# Notice of Modification

## Section 4.55(1A) of the *Environmental Planning and Assessment Act 1979*

The Development Consent for the Sunraysia Solar Farm (SSD 7680) granted by the Executive Director, Resource Assessment and Business Systems, as delegate of the Minister for Planning, on 20 June 2017.

APPENDIX 1: General Layout of Development

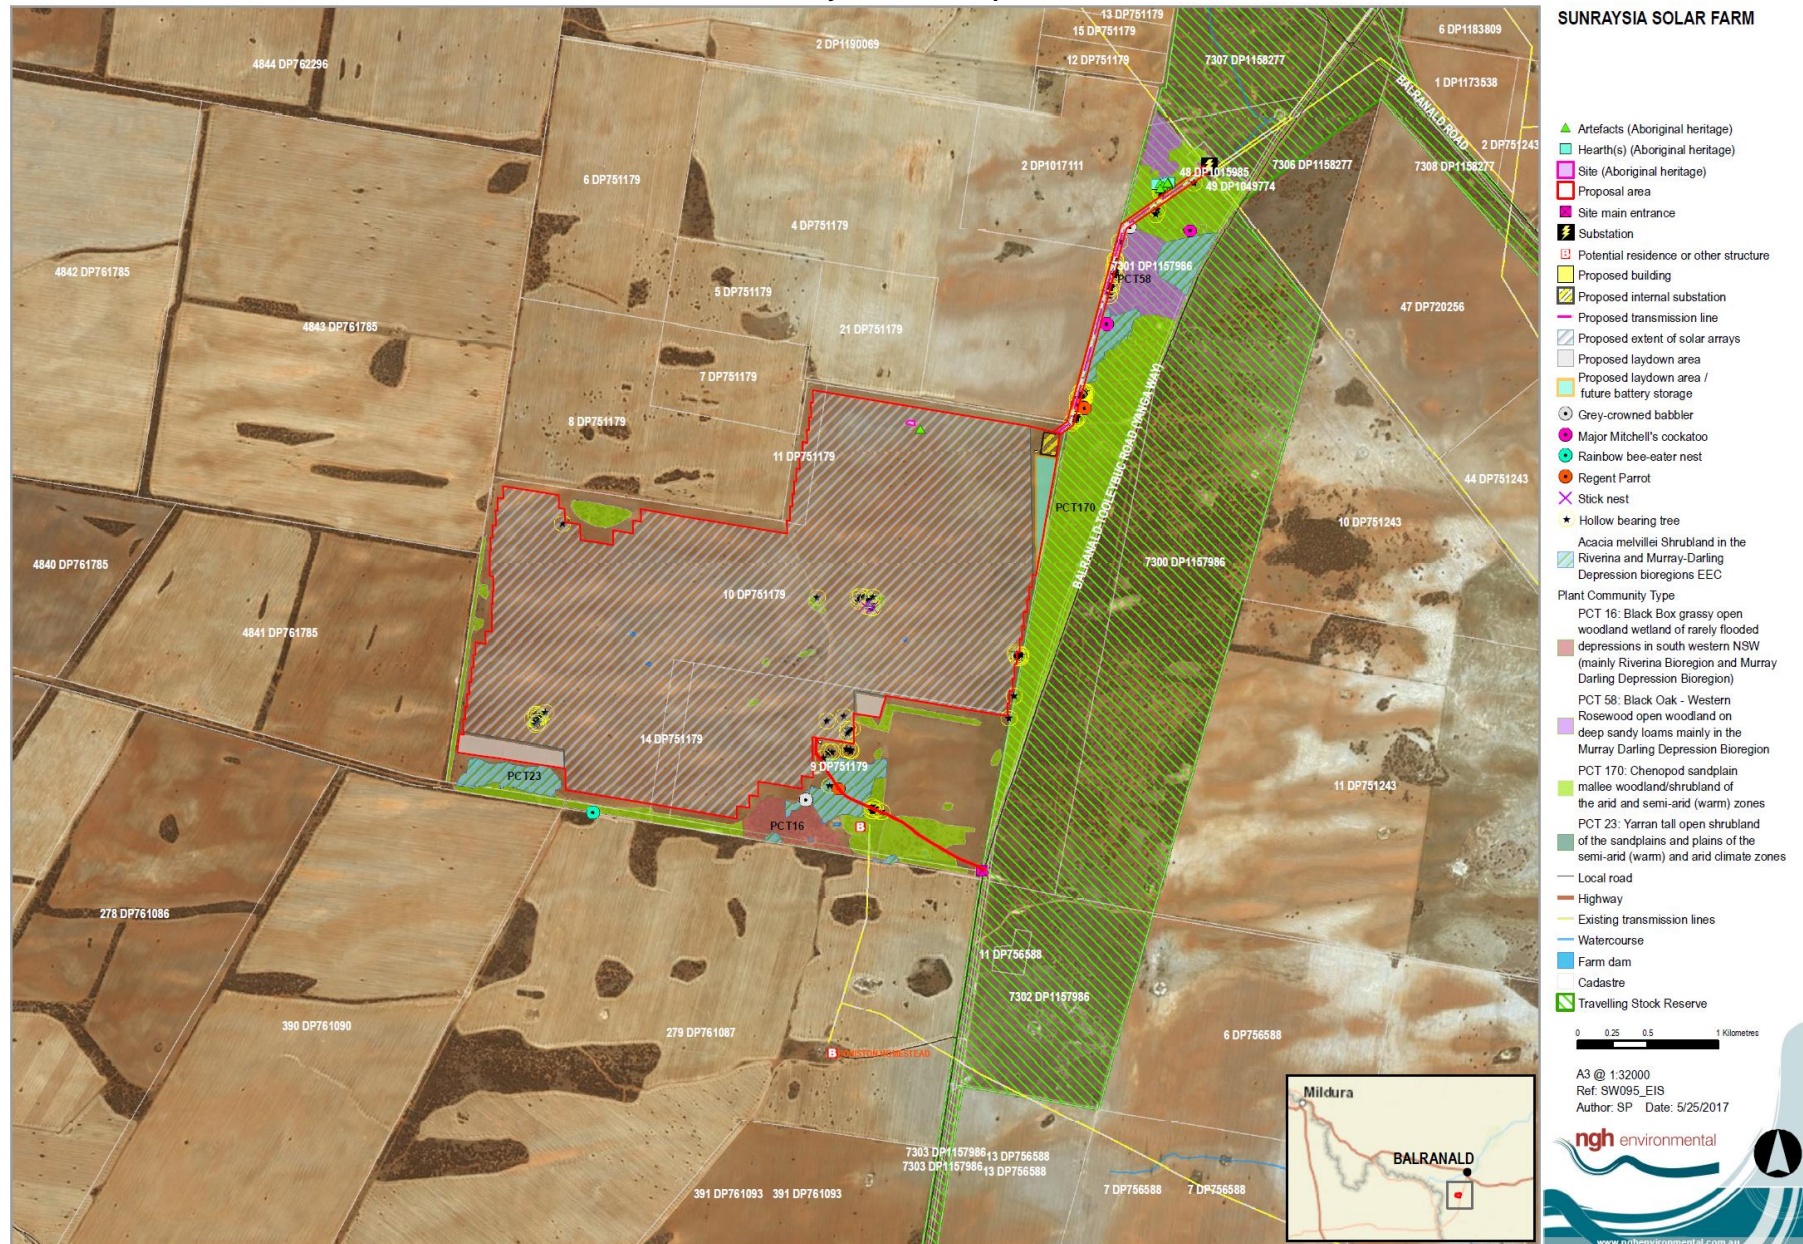
8. Delete the figure in Appendix 1 and replace with the following:
